Application for Planning Permission for Works or Extension to a Dwelling

Development Demolition of existing stables, construction of new shed and gym on higher ground

Location The Cottage Brookside Road Kingston

Existing Block Plan

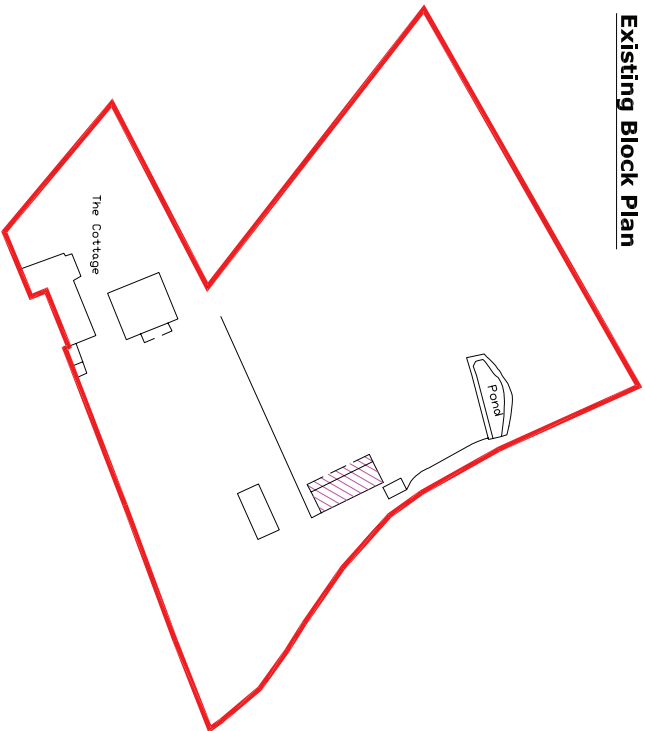
Please send revised block plans making it clear 'existing' & 'proposed' and to include measurements to each boundary from the proposal
